DEVELOPMENT REVIEW BOARD
TRANSPORTATION DEVELOPMENT

DRB Project Number: 1003991
Sage Ranch Subdivision

SUBJECT: Preliminary Plat, Sidewalk Deferral, Vacation Of Public Easements, Vacation Of Public Right of Way
+ SW waiver

DRB Project Number: 1003991 Hearing Date: 03-21-2018
 Project: Sage Ranch, Lots 1 - 26 Agenda Item No: 1

PRELIMINARY PLAT FOR
SAGE RANCH SUBDIVISION
 WITHIN THE
 TOWN OF ATRISCO GRANT
 PROJECTED SECTION 33
 TOWNSHIP 10 NORTH, RANGE 2 EAST, NMPM
 CITY OF ALBUQUERQUE
 BERNALILLO COUNTY, NEW MEXICO
 DECEMBER, 2017

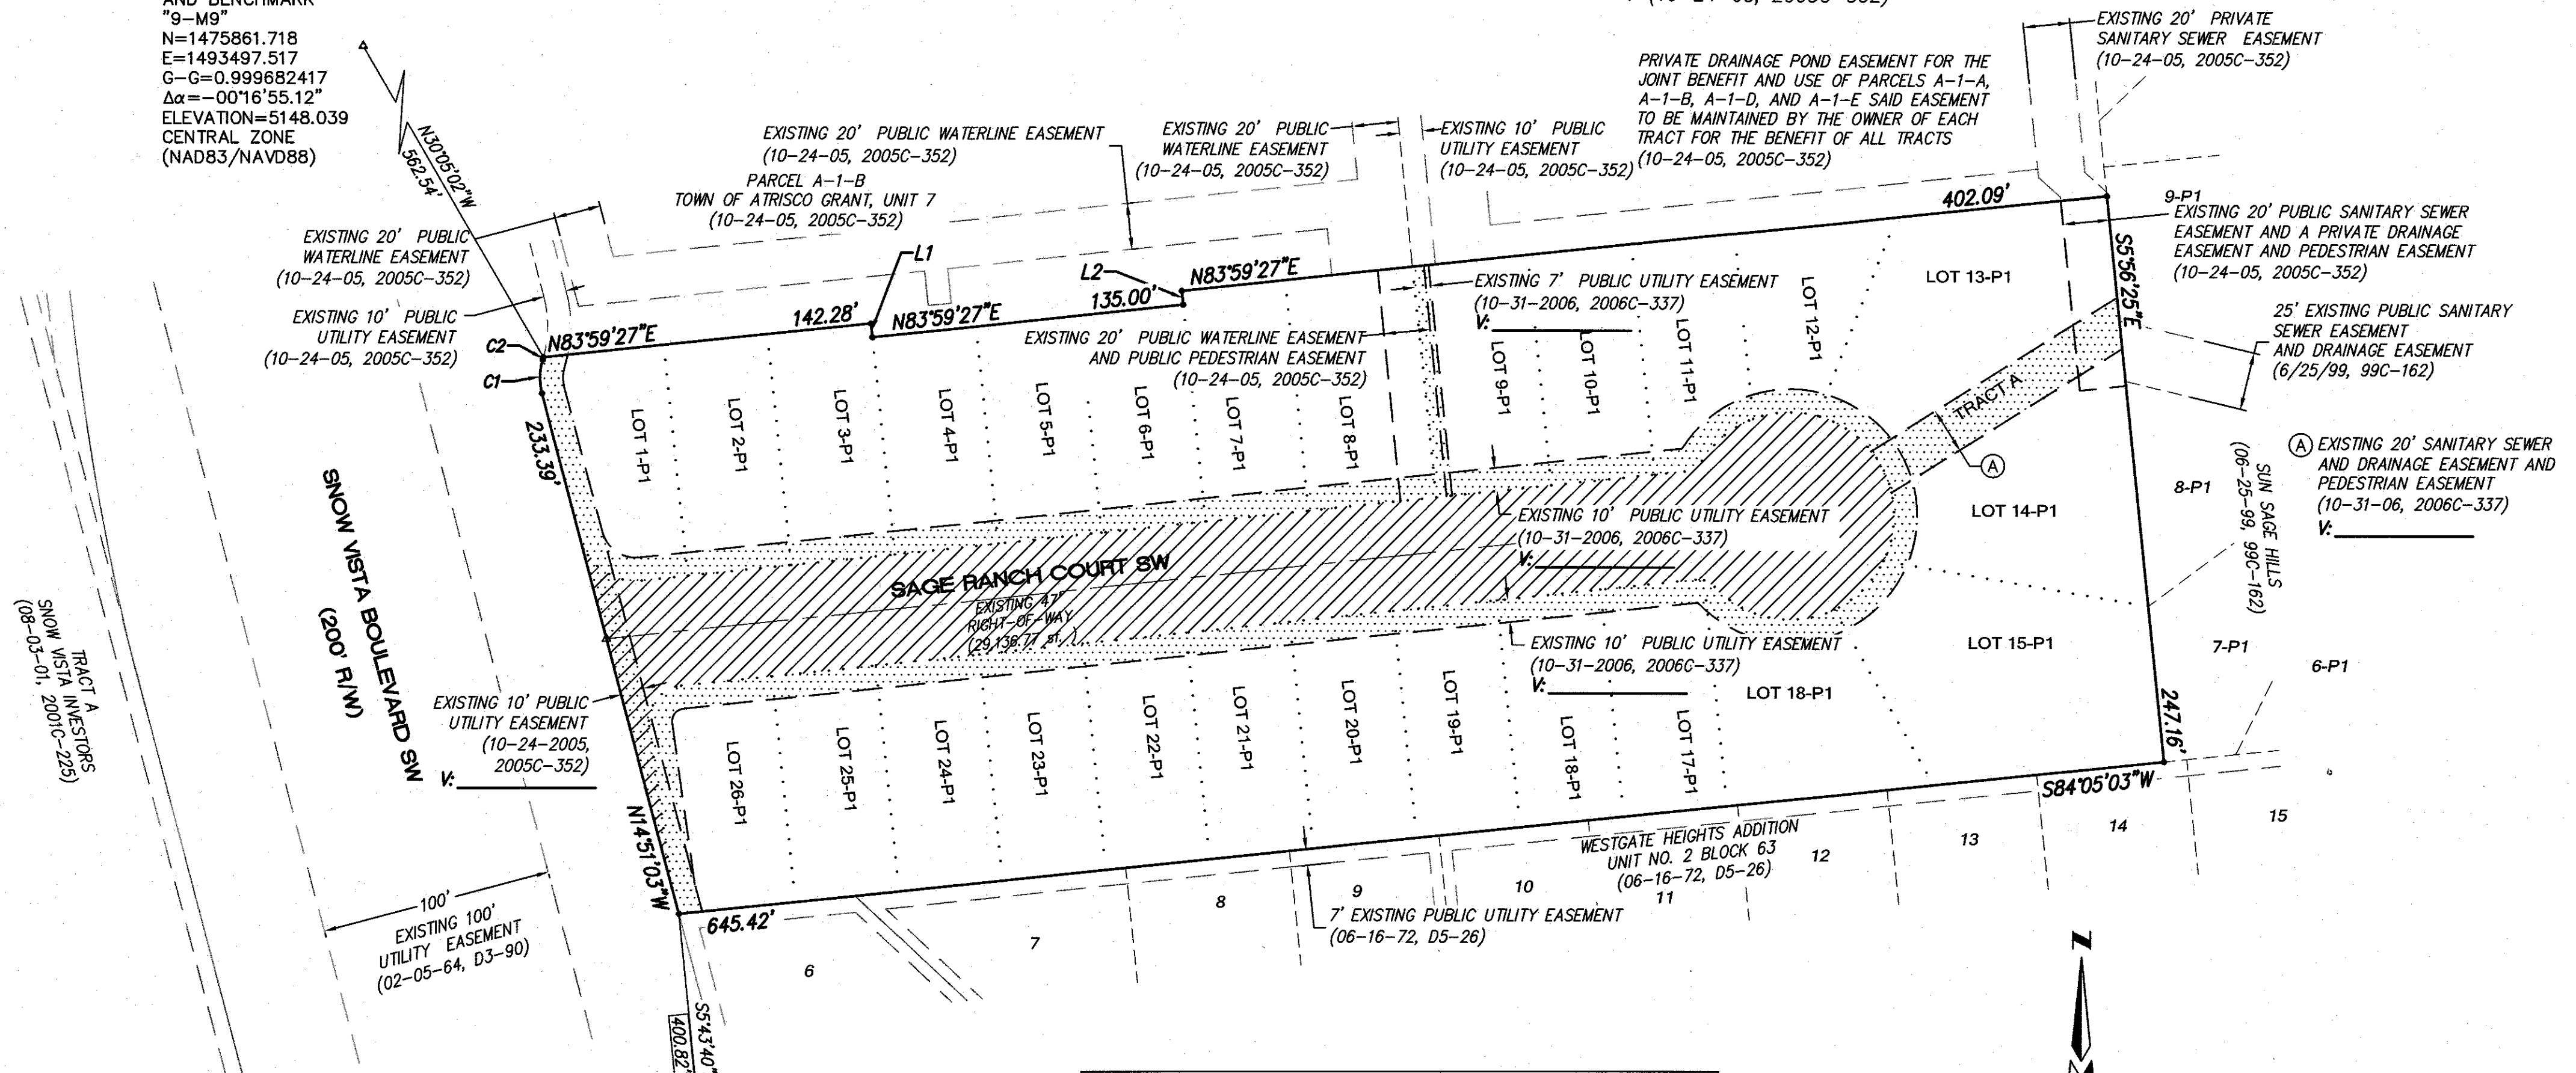
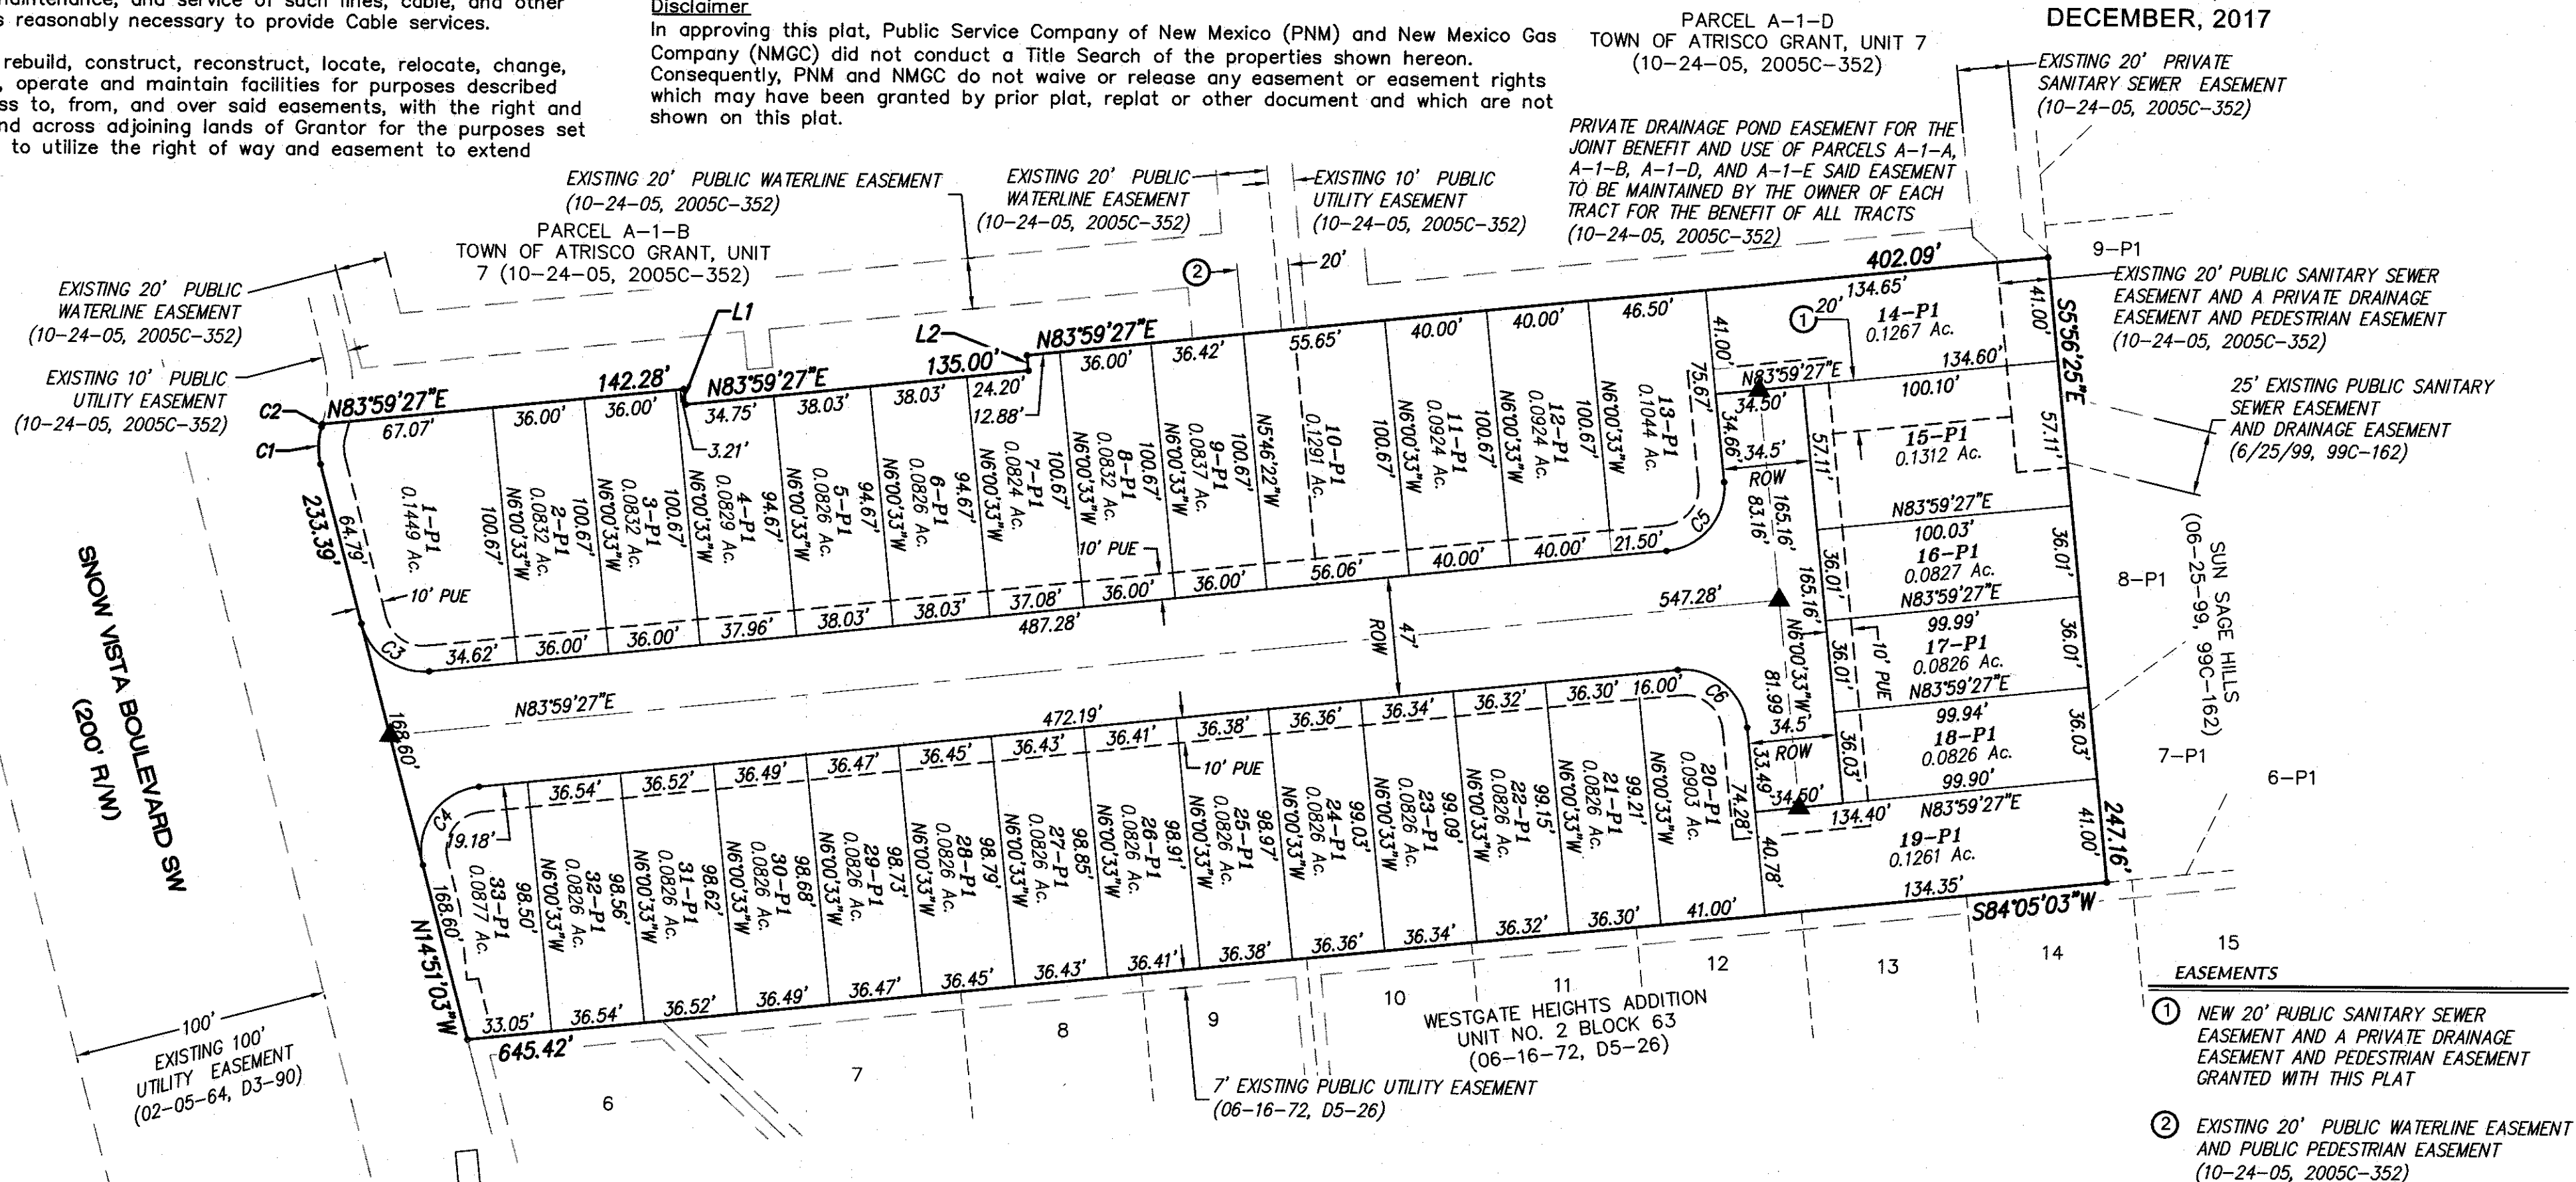
1. Sidewalks are required along all lot frontages, including lots 13-P1 and 19-P1 and the hammerhead ends. Provide an application and justification for sidewalk waiver.
2. Add the pavement, curb, gutter and sidewalk for the hammerhead to the infrastructure list.
3. Add the ADA ramps on 98th St. to the infrastructure list.
